CITY OF ALBUQUERQUE

**Re: Everglades Building (Juan Tabo Office), 5123 Juan Tabo NE,
Permanent Certificate of Occupancy - Approved
Approved Engineer's Stamp Date 7-09-09
Certification dated 9-08-09 (F-21/D033)**

RE: **Everglades Building (Tract D-3) 5123 Juan Tabo NE (MAP F21- D 033)**
Grading & Drainage Plan for Site Plan & Building Permit (PE Stamp 07-03-08)

RE: **Everglades Building (Tract D-3) 5123 Juan Tabo NE (MAP F21-D 033)**
Grading & Drainage Plan for Site Plan & Building Permit (PE Stamp 05-08-08)

GRADING AND DRAINAGE PLAN

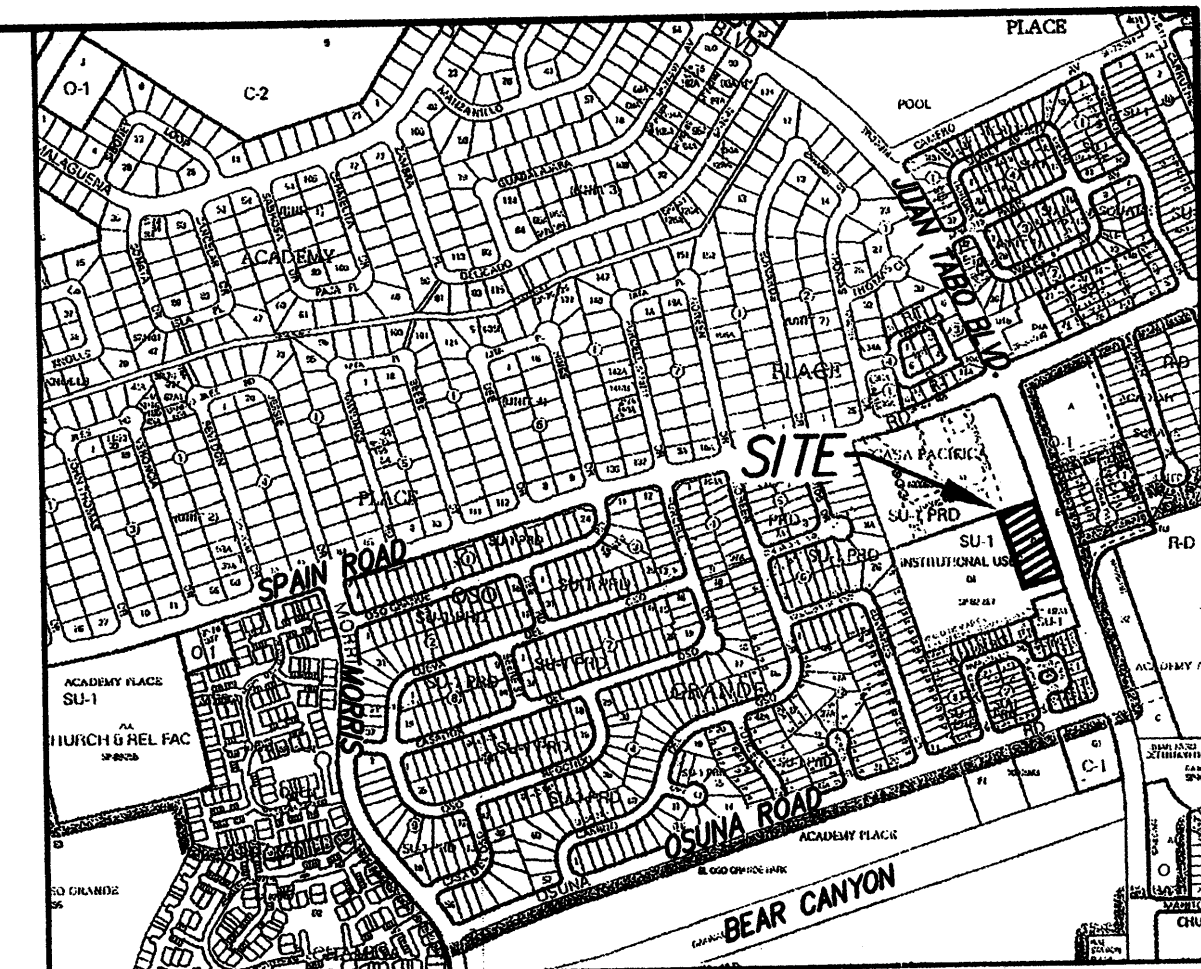
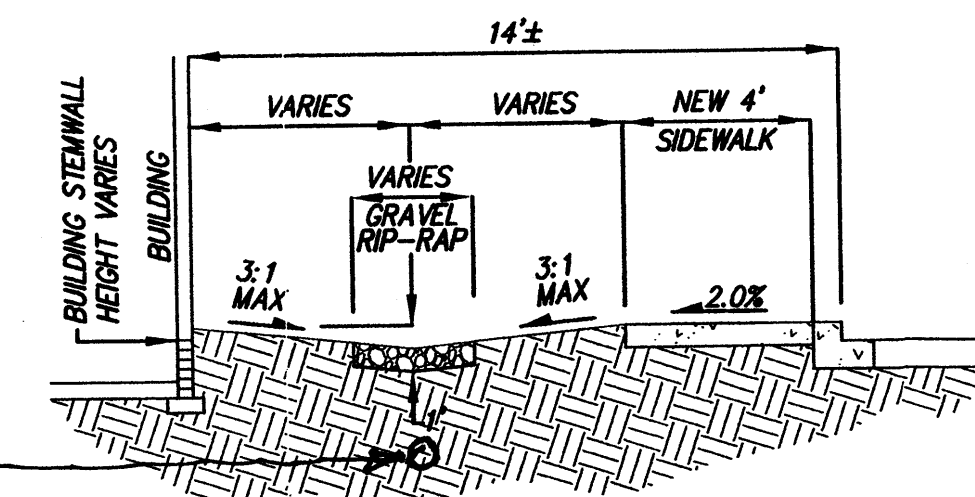
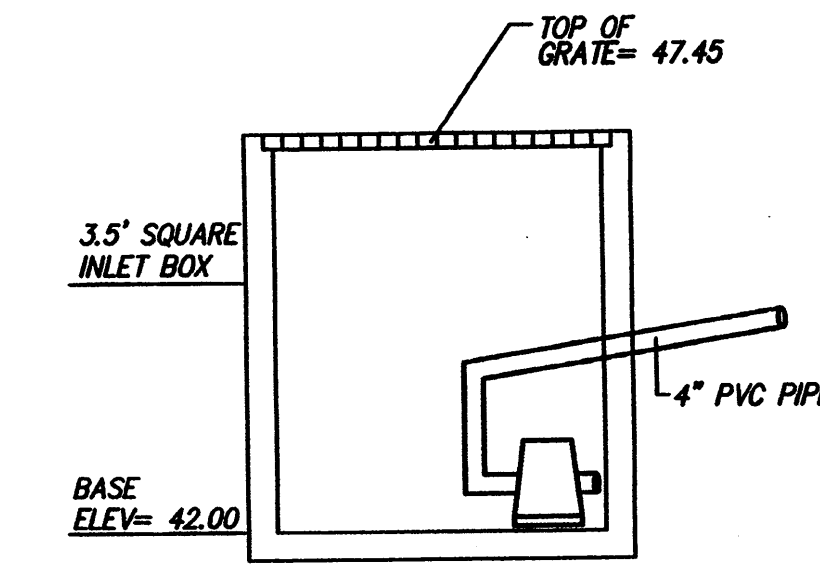
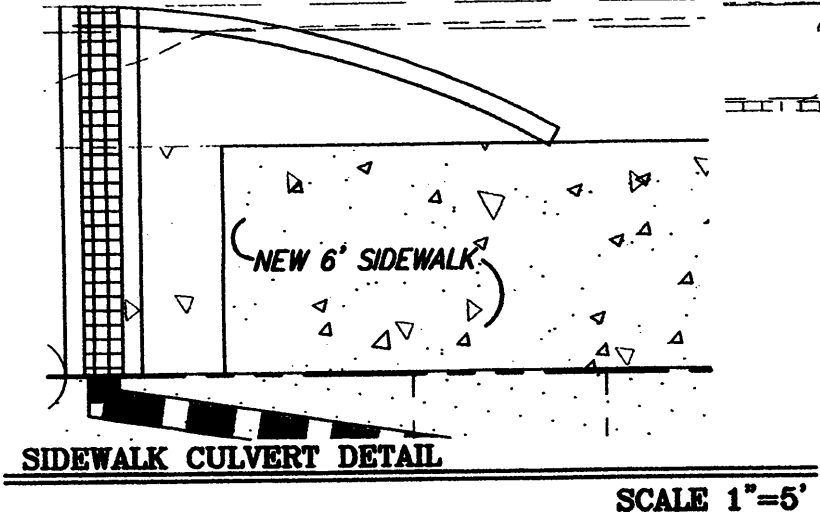
- 1) This drainage submittal lacks several critical items of information necessary for our review (refer to DPM Chapter 22, Section 7). Of particular concern are a narrative discussion of existing and proposed flow conditions and outfall discharge rates, accompanied by calculations to support flow rates and ponding volumes.

- 2) The plan shows a portion of the existing graded site discharging westerly to Tract D-1, with the proposed plan constructing retaining walls to keep flows on site. Provide cross sections and details for proposed wall locations, and easements if offsite grading is required for wall construction.

- 3) Near the SE corner of the circular parking area, the landscape drainage invert at the back of sidewalk appears to be below the sidewalk elevation. A pipe or culvert is required to convey flows under the sidewalk.

- 4) The landscaped area north of the east building entrance appears to require a retaining wall, similar to that south of the entrance, as grades result in over 2-to-1 slopes at the back of the adjacent, public sidewalk.

- 5) The Summary of Hydrology indicates a Maximum Water Surface Elevation of 5749.27. This water level will pond against the retaining wall, which must provide a minimum 1.0 foot of freeboard. The currently specified TW = 5749.30 is not adequate. Also, the tie

to existing Railroad Tie Retaining Wall on the west side of the lot must be revised to provide the necessary freeboard, which cannot be provided by the R.R. Ties.

- 6) The 4" pipe connection to the curb at the NE corner of the site is not acceptable, as it will be discharging 450 gpm at over 11 ft/sec into Juan Tabo traffic. An alternate detail like a sidewalk culvert is suggested, to reduce the energy of flows entering Juan Tabo.

- 7) Provide details of the "SO-19" connection to the curb on Juan Tabo and refer to the Notice To Contractor requirements on this plan.
- 8) I have operational concerns for the proposed pump and discharge piping; review and amend as appropriate for:

- a) Is there a check valve in the discharge line?
 - b) The 1.0 cfm sump pump will empty the 1 foot on-off head depth within the sump in only 12 seconds. Will the pump cycle on-off too frequently during low flows?

- c) Will the water standing in the pump discharge line freeze during winter months of non-use? No pipe bury depth was specified.
- 9) Since this site exceeds 1 Acre, a Storm Water Pollution Prevention Plan (SWPPP) will be required. Effective July 1, 2008, a SWPPP must be included with the submittal for a Rough Grading, Grading, Paving or Building Permit. The SWPPP must be in PDF or MS Word format on a CD.
